**2022/1178**

Erection of extension to existing building to create additional unit (B2 General Industry and B8 Storage and Distribution) and creation of additional parking

Unit 3, Everill Gate Business Park, Everill Gate Lane, Wombwell, Barnsley, S73 0FJ

Site Layout
Revised turning area

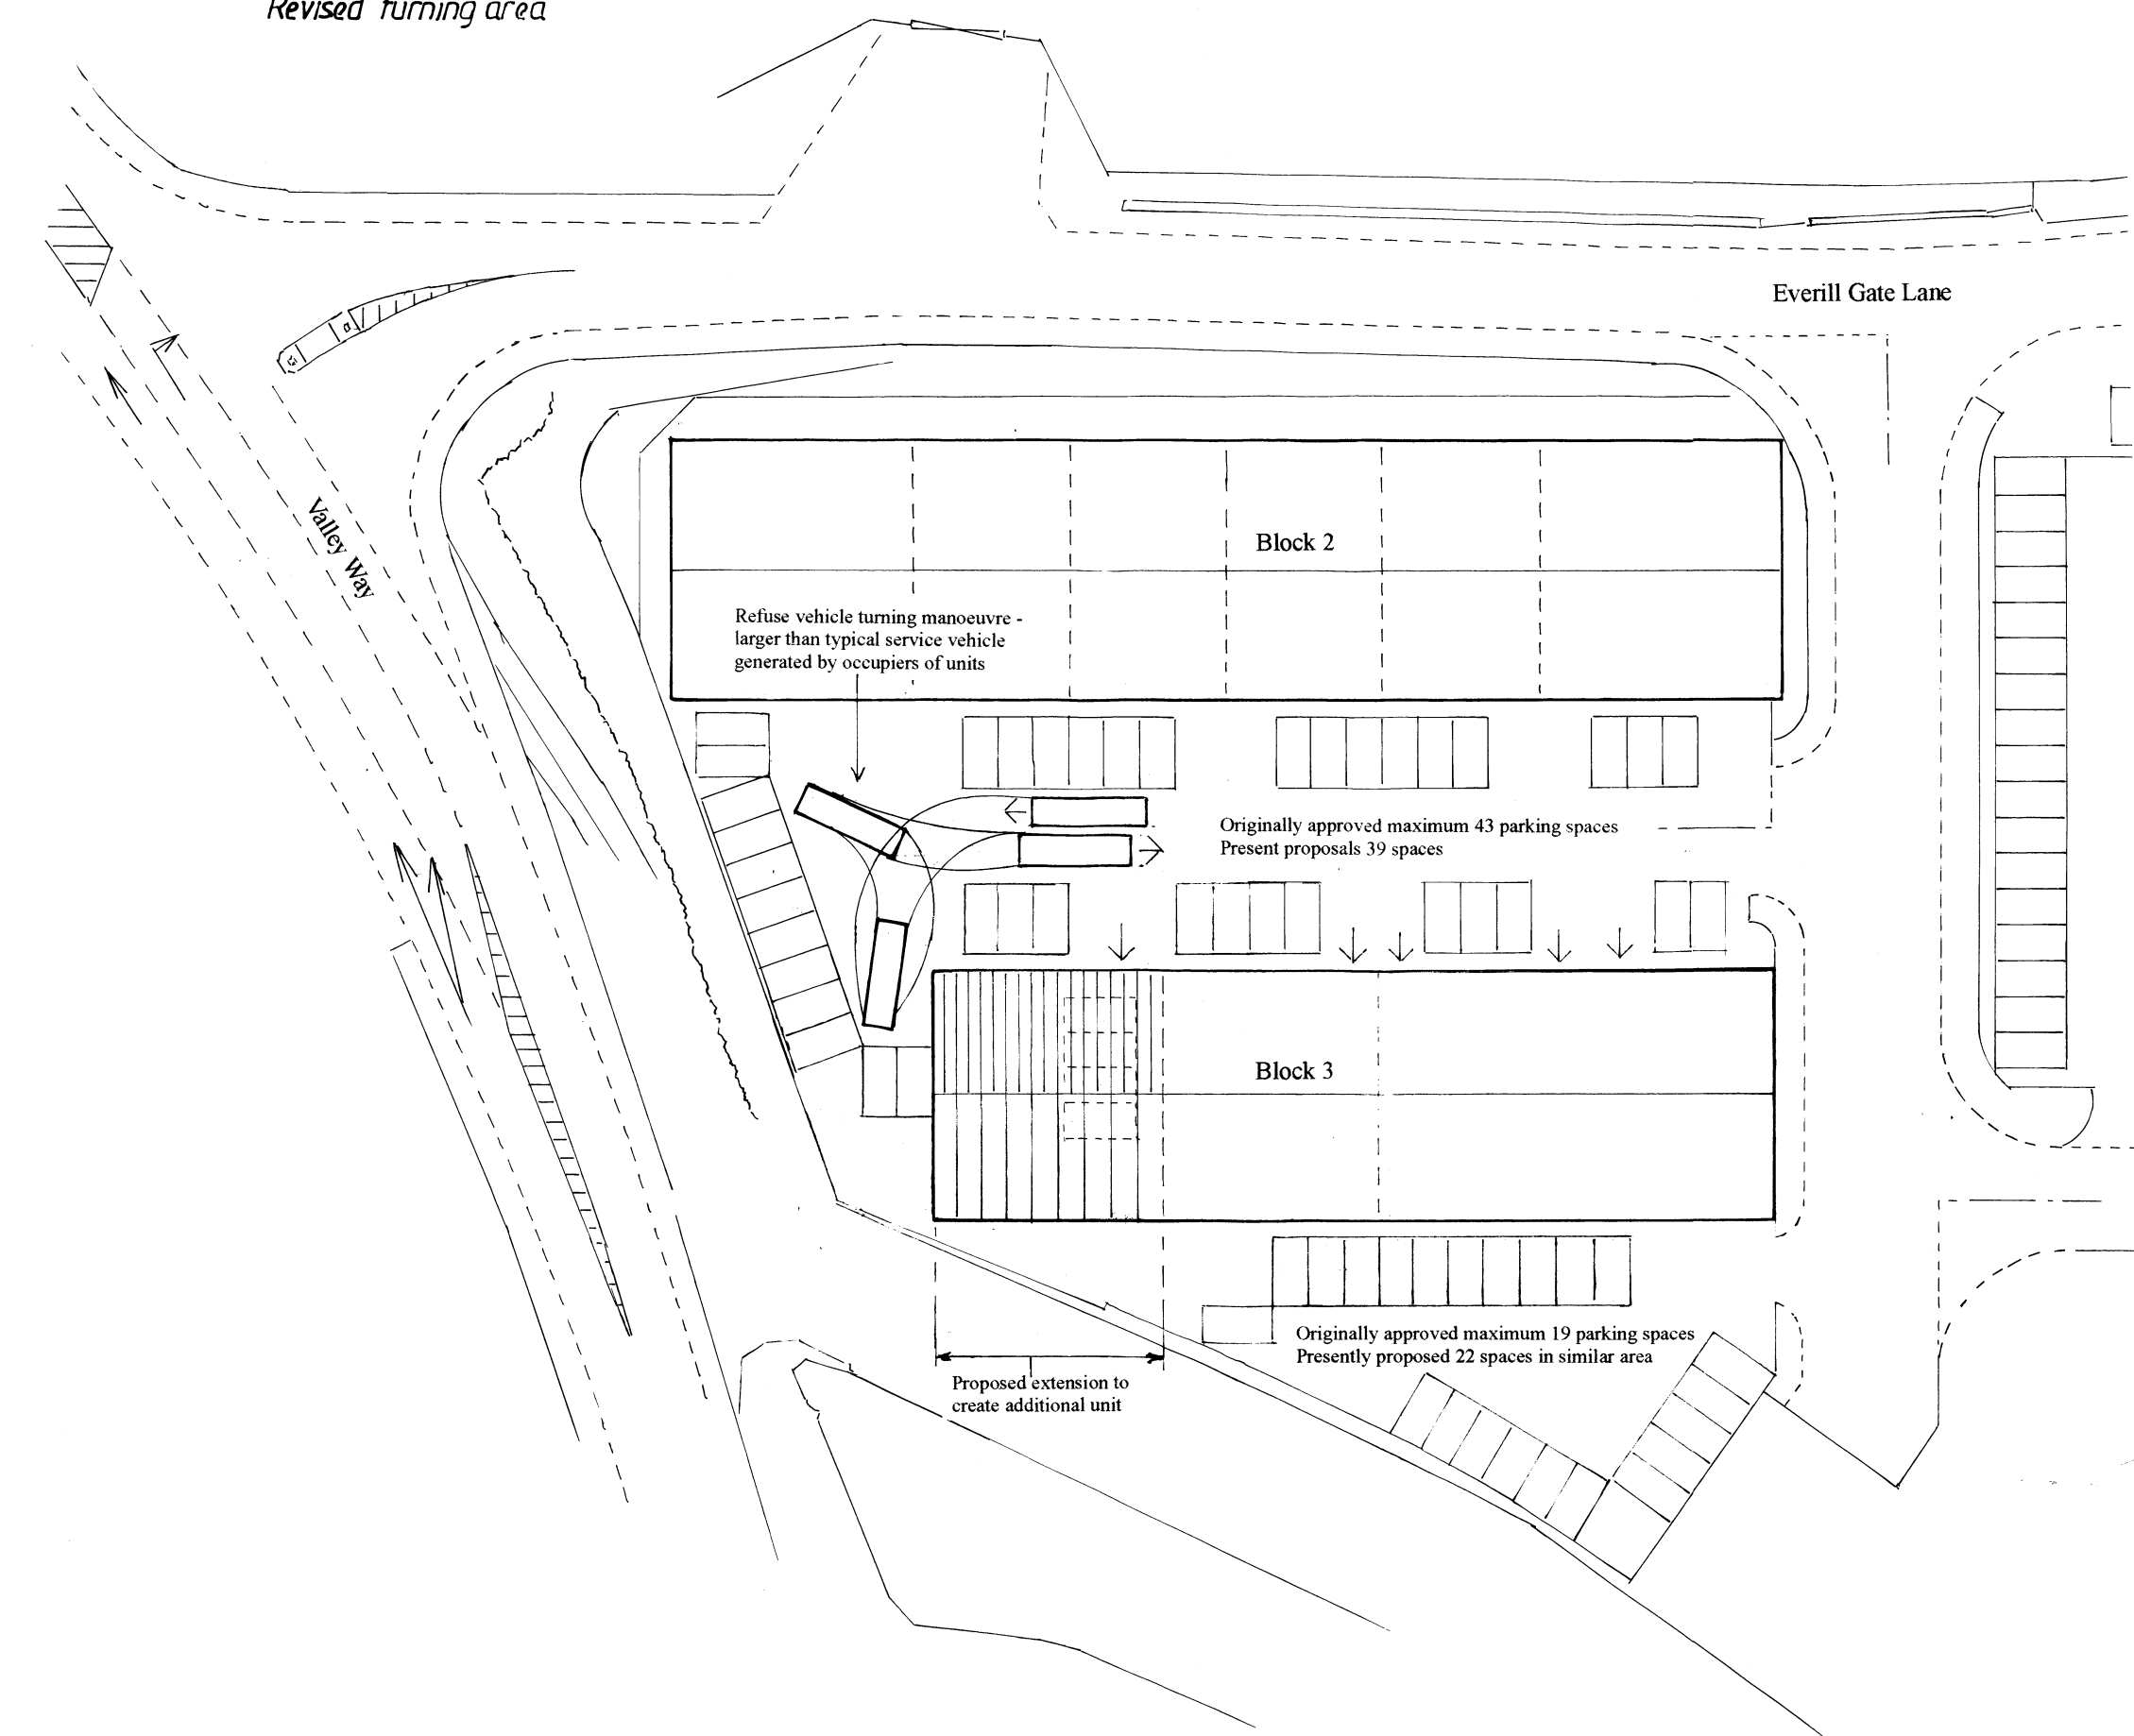
Following consultation with Highways an amended site layout has been submitted with parking amended to allow for sufficient turning facilities. In terms of car parking provision, the agent has stated that 'as far as car parking is concerned the original planning permission showed a maximum of 43 spaces whilst the proposed development will provide 39 spaces to allow space for the turning of service vehicles. In so far as the original number of spaces was a "maximum" I presume that a reduction of four spaces will make no difference. However please note that the land to the south of the units was originally shown as providing a maximum of 19 spaces whilst a slight revision to the parking layout now shows that it can accommodate 22 spaces. Overall therefore there is only a reduction of one space compared with the maximum number of spaces agreed at the time of the original planning permission.'

Following consultation with Highways an amended site layout has been submitted with parking amended to allow for sufficient turning. The agent has stated that 'the amended plan shows the turning manoeuvre of a refuse vehicle which is significantly larger than the service vehicles (generally Ford Transit size) that typically serve the units on this development. As far as car parking is concerned the original planning permission showed a maximum of 43 spaces whilst the proposed development will provide 39 spaces to allow space for the turning of service vehicles. In so far as the original number of spaces was a "maximum" I presume that a reduction of four spaces will make no difference. However please note that the land to the south of the units was originally shown as providing a maximum of 19 spaces whilst a slight revision to the parking layout now shows that it can accommodate 22 spaces. Overall therefore there is only a reduction of one space compared with the maximum number of spaces agreed at the time of the original planning permission.'

The Highways Officer has considered the amended plans and parking provision and has no objection to the proposal subject to condition. The proposal provides sufficient parking and manoeuvring facilities and is in accordance with policy T4 of the Local Plan.
